CITY OF ALBUQUERQUE

October 4, 2021

Re: Chipotle Mexican Grill
1000 Juan Tabo Blvd NE
Traffic Circulation Layout
Architect's Stamp 09/29/2021 (J22-D012D)

## TRAFFIC CIRCULATION LAYOUT PLAN

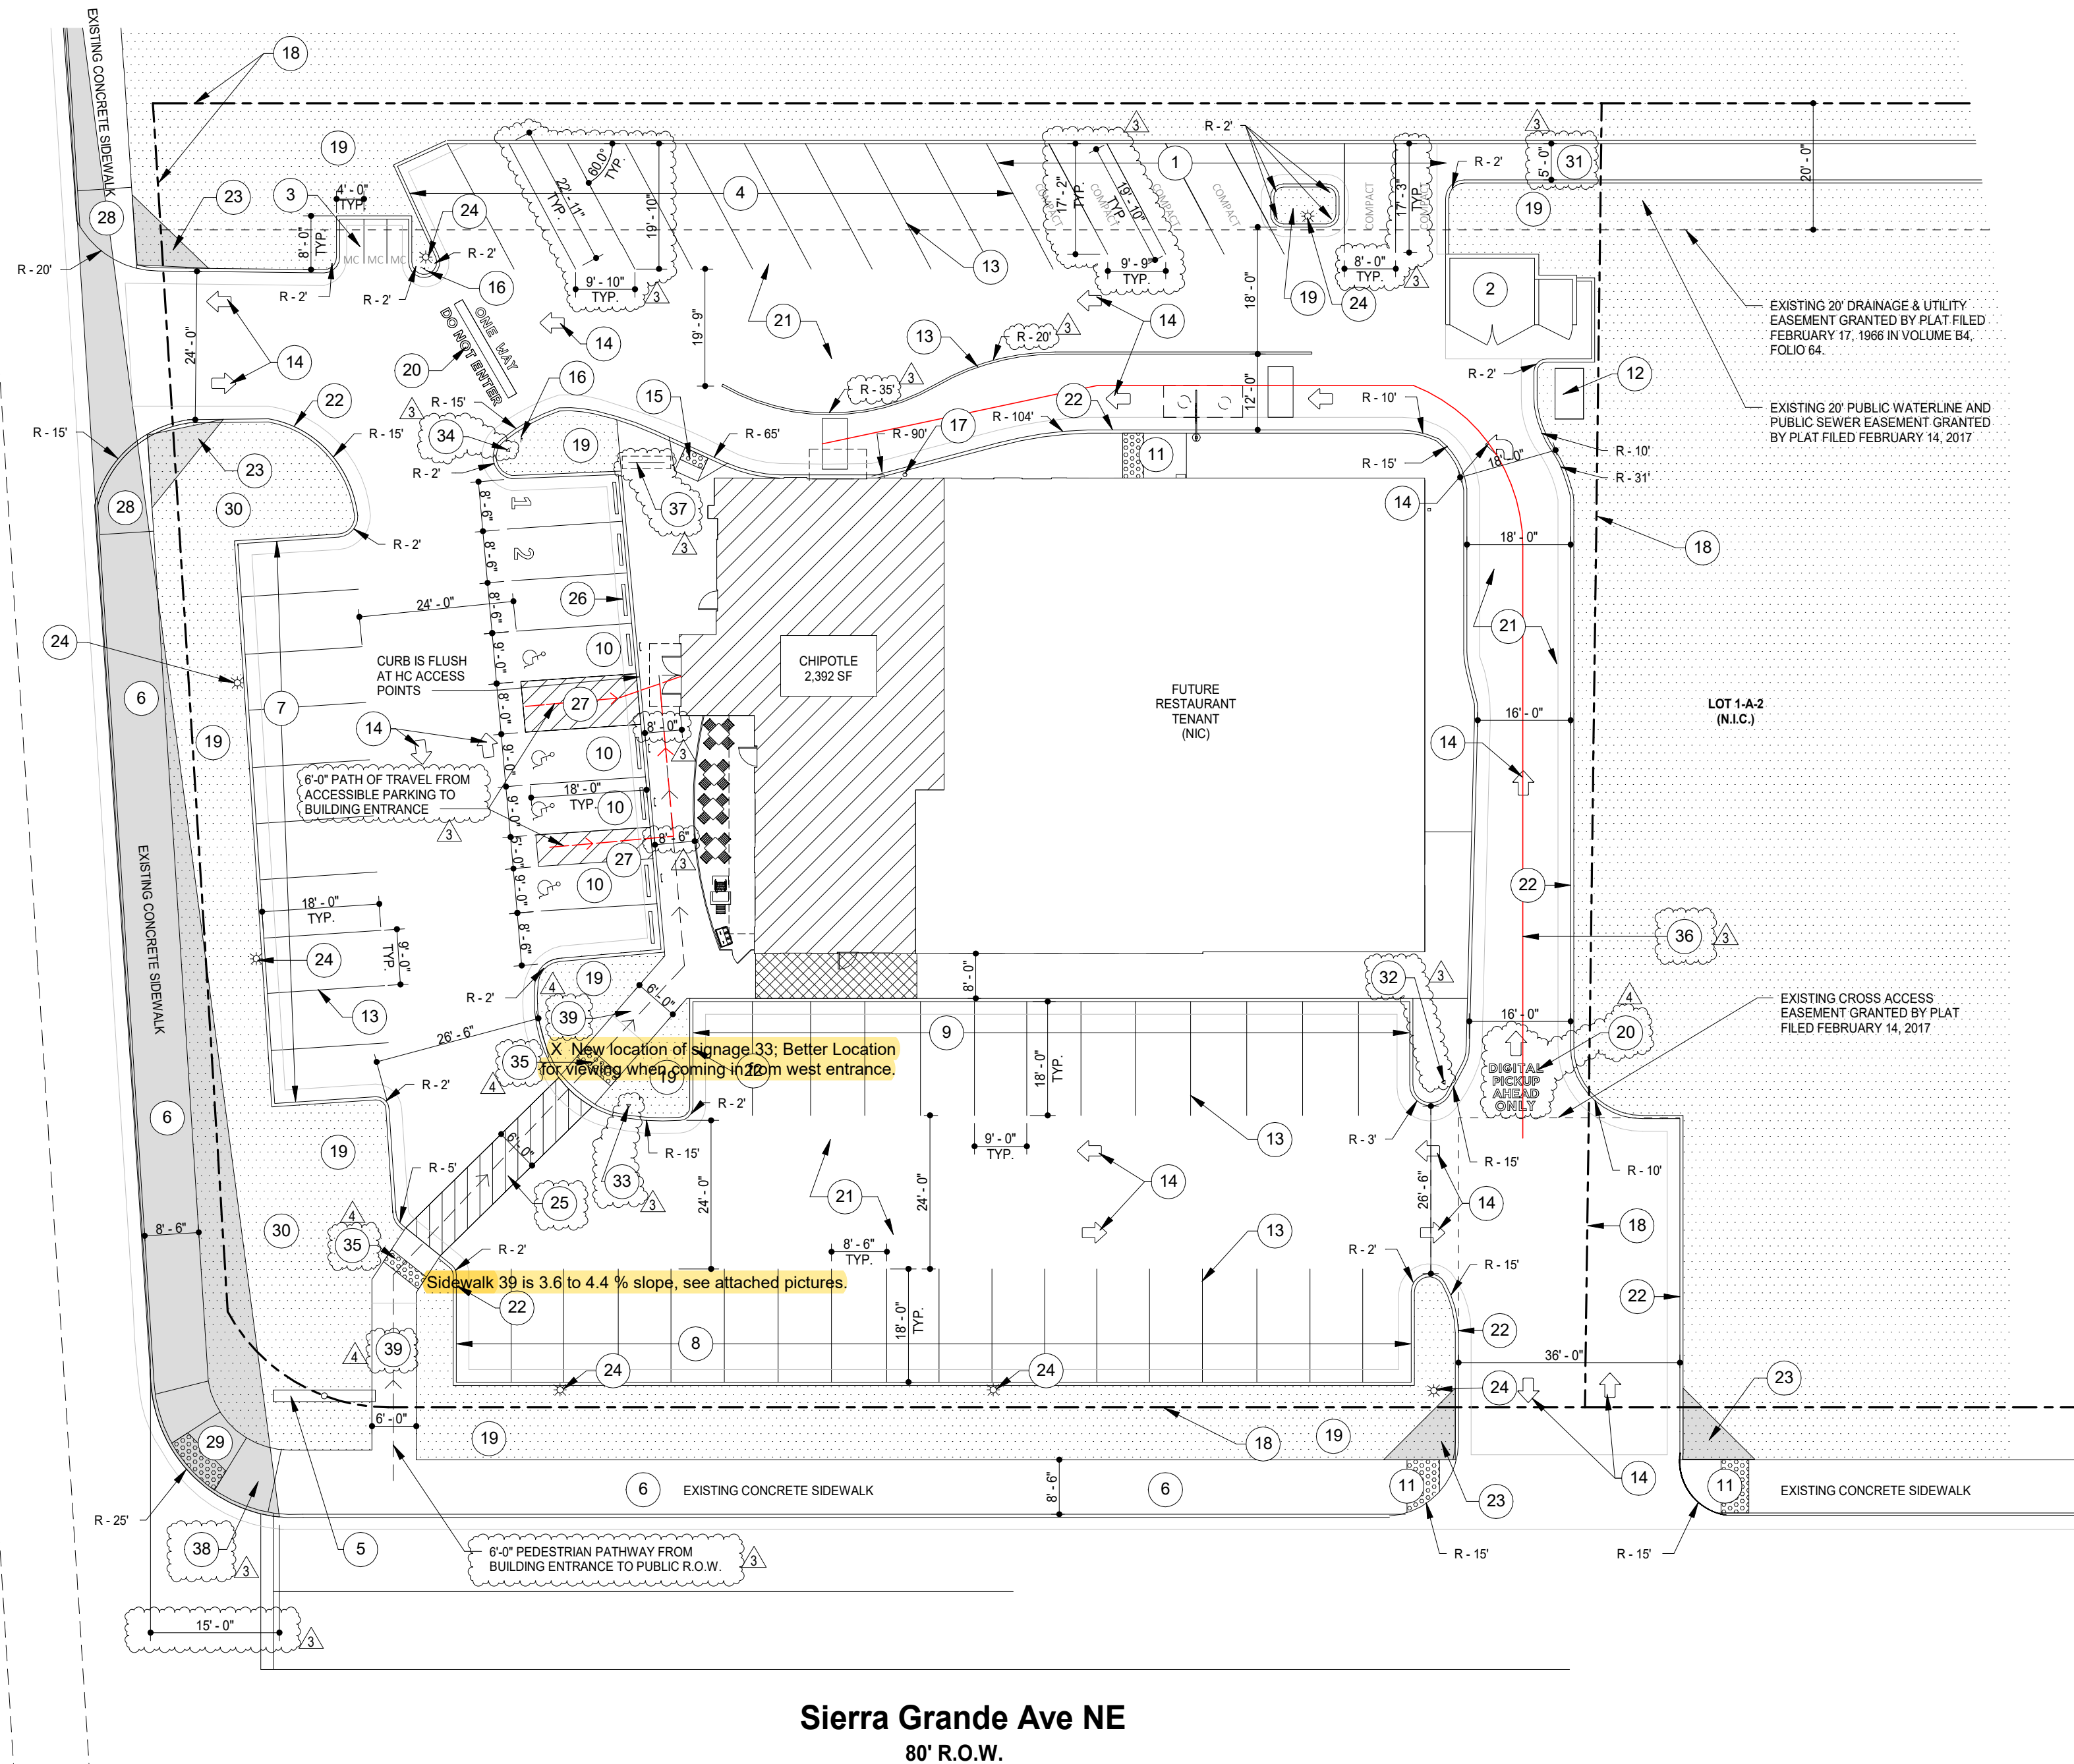
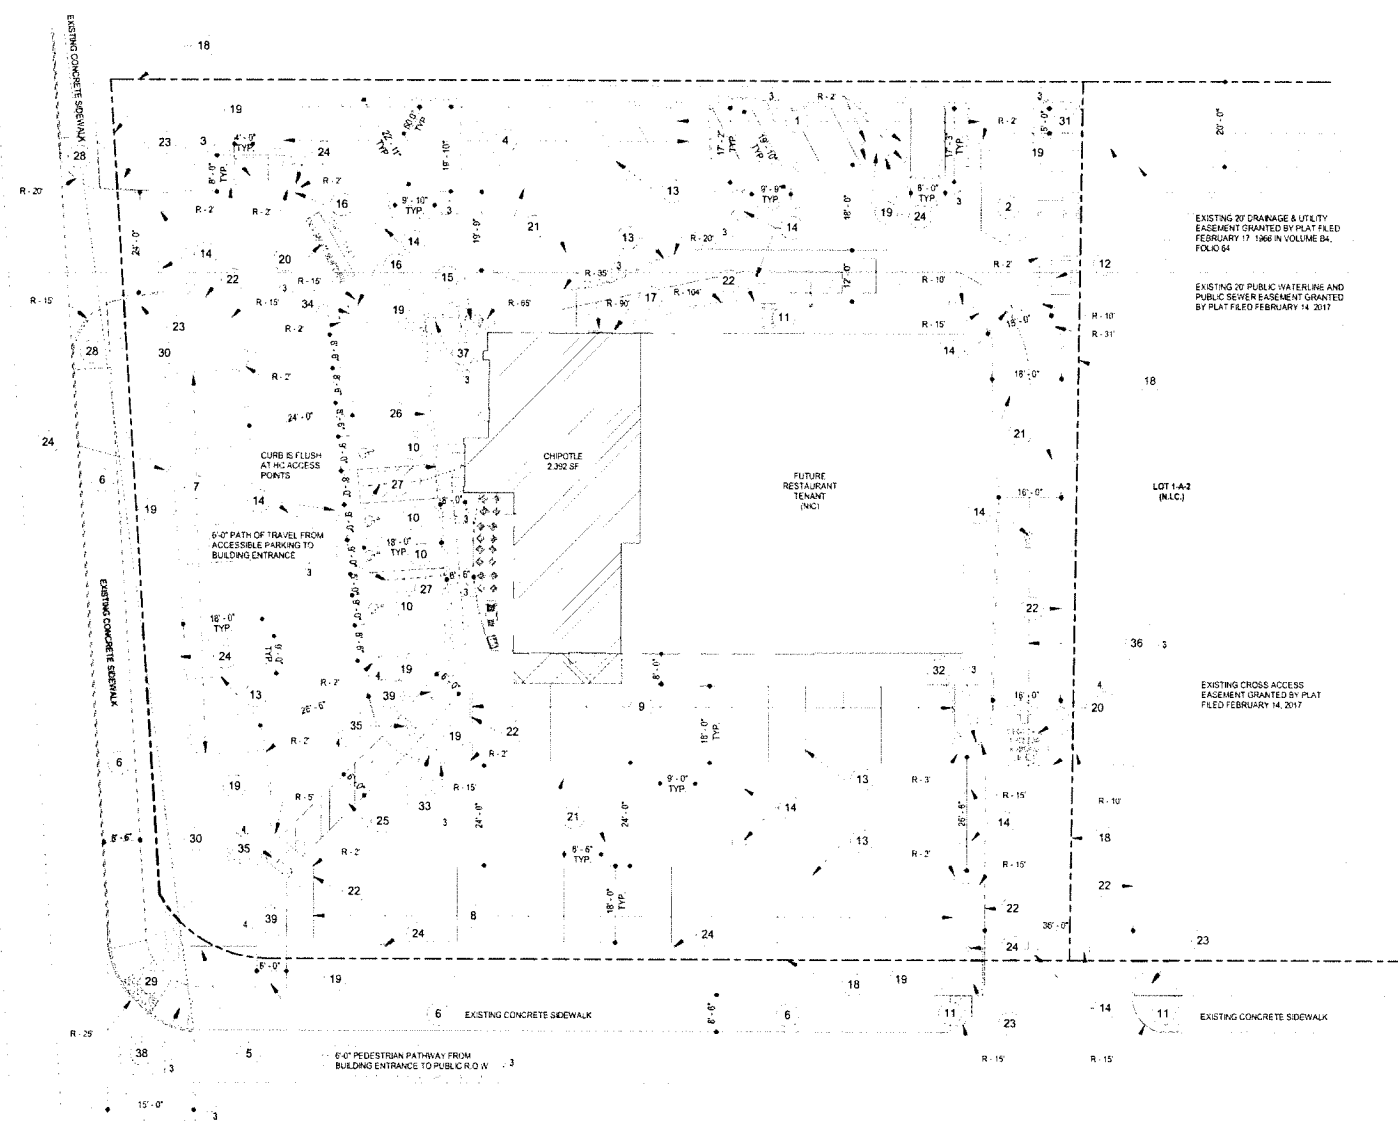
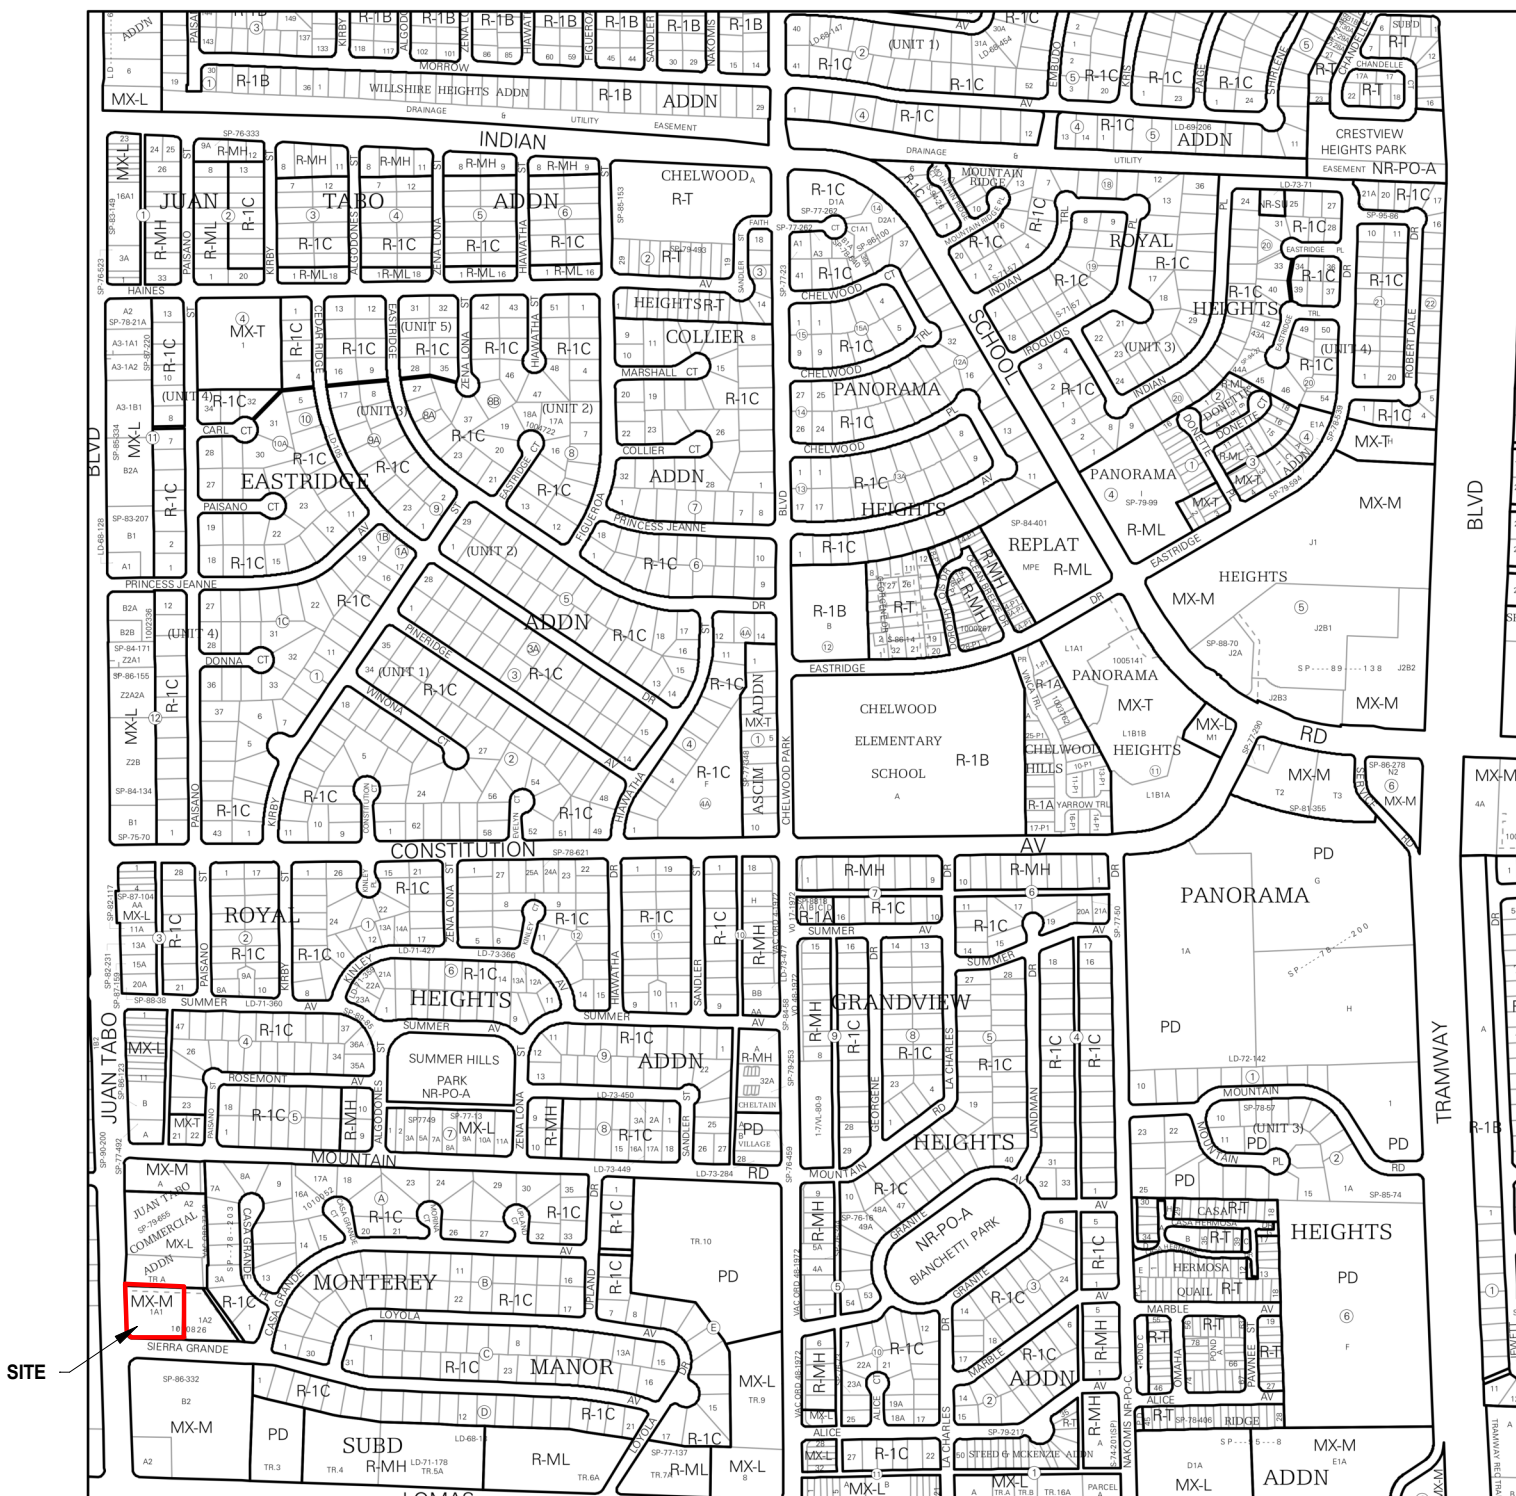
2. **An open pathway on existing 20'-0" Drainage/Utility on northeast corner of property shown but no notes to identify it purposed/function. A note will need to be provided.**

3. **Drive thru lane (Existing):**
 - A queuing length will need to be provide from order menu to window. The queuing length will need to follow DPM requirements.

- The order menu board is not shown to determine the total queuing length.
4. **Keyed Note 4:** Please provide angle to determine if existing diagonal parking dimensions are adequate base on angle **(Per DPM requirements)**.

5. **Keyed Note 5:** Exiting Plyon Sign appears to be partially located within COA ROW. So, Any private structures that are located within public right-of-way such as fences and walls shall either be removed or else a revocable permit with the City is required in which an annual fee is paid per year, based on square footage of the encroachment. This includes Air Space.

6. **Keyed Note 14:** Rephrase Directional Signage to Directional Pavement Markings as shown on site plan.
7. **Keyed Note 15:** Explain the proposed ADA ramp because it doesn't properly service ADA since there isn't another ADA pathway shown.

8. **Keyed Note 16:** Details will need to be provided for sign face and post.
9. **Keyed Note 20:**
 - Rephrase statement from Signage to Pavements Markings.

- Details will need to be provided for Pavements Markings.

10. **Keyed Note 11:** The existing parallel ADA curb ramps will need to be current/update ADA compliant. Verify these requirements.
11. Adjacent to Keyed note 20 is a black bar on landscaping area and no label to identify its function. **Provide some type of note to identify.**
12. Please list the width and length for all existing and proposed parking spaces. Some dimensions are not shown.

14. The ADA accessible parking sign: So which detail will be used for this project detail 4 or detail 8 (preferred)? Because of the required language per 66-7-352.4C NMSA 1978 **"Violators Are Subject to a Fine and/or Towing"**

15. ADA curb ramps must be updated to current standards and have truncated domes installed within COA ROW. Verify existing ramp are up to date and if not remove/replace with the most current and update ADA ramps. Remove all references to NMDOT standard since ROW is within City of Albuquerque jurisdiction.

16. **Motorcycle parking spaces:** Shall be designated by its own conspicuously posted upright sign, either free-standing or wall mounted per the zoning code. Label pavement MC.

21. Show all drive aisle widths (**between Refuse enclosure and drive thru lanes**) and radii (**drive thru striping**). Some dimensions are not shown.

24. Per the IDO, a 6 ft. wide ADA accessible pedestrian pathway is required from the public sidewalk to the building entrances. Please clearly show this pathway and provide details. **It appears that proposed patio tables might reduced this pathway width. Verify and adjust and address this concern.**

25. Per DPM, a 6 ft. wide ADA accessible pedestrian pathway is required from the ADA parking stall access aisles to the building entrances. Please clearly show this pathway and provide details. **It appears that proposed patio tables might reduced this pathway width. Verify and adjust and address this concern for the 5 ft access aisle pathway to building entrance.**

26. Refuse vehicle maneuvering shall be contained on-site. The refuse vehicle shall not back into the public right of way. Provide a copy of refuse approval.

27. **All one-way drives shall have “One Way” and “Do Not Enter” signage and pavement markings. Please show detail and location of posted signs and striping.**

28. **The minimum drive through lane width is 12 feet with a 25 foot minimum radius (inside edge) for all turns.** (A 15 foot radius can be used with an increase in lane width to 14 feet). Please dimension all lane widths and radii.

29. What is the size of the Clear Sight Triangle at corner of Juan Tabo/Sierra Grande? Provide on site plan.
30. **Shared Site access:** Driveways that straddle property lines, or are entirely on one property but are to be used by another property, shall have an access easement. Please include a copy of your shared access agreement with the adjacent property owner or Provide copy existing PLAT specifying cross access easement.

31. Unused curb cuts must be replaced with sidewalk and curb & gutter. A build note must be provided referring to the appropriate City Standard drawing (2430 & 2415A).

32. Add a note stating **“All broken or cracked sidewalk must be replaced with sidewalk and curb & gutter.”** A build note must be provided referring to the appropriate City Standard drawing (2430 & 2415A).

33. **All existing pavement markings will need to be clean/clear and not deteriorated.** If deteriorated please provide note to paint existing pavement markings.
